Response to Planning Application

From: Arun District Council Greenspace

Application ref: LU/206/21/RES

Description: Approval of reserved matters following outline consent LU/47/11/ for the development of 261 No. dwellings, the formation of green swale (SuDs feature) and the construction of part of the Central Spine Road running through Phase 5 at Hampton Park and southwards to link up with Toddington Lane. This site is in CIL zone SP2 and is not CIL Liable as strategic site

Landscape Strategy: Play - LEAP

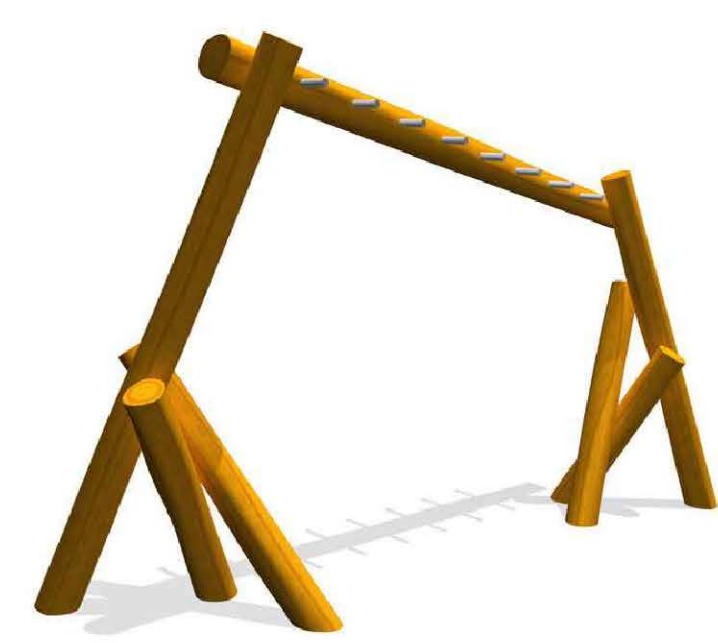
Further to receipt of details relating to **LU/206/21/RES amended LEAP detail plan LA.PH5-8.1 Rev E received 14/03/2022** I would comment as follows

No Objection - The amended play equipment as detailed in the LEAP dwg LA.PH5-8.1 Rev E will provide an inclusive and accessible play offer with a variety of differing play experiences, compliant safety surfacing, seating and bins. The amended landscaping scheme includes a suitable mix of evergreen and deciduous mixed ornamental and native species and a number of larger trees.
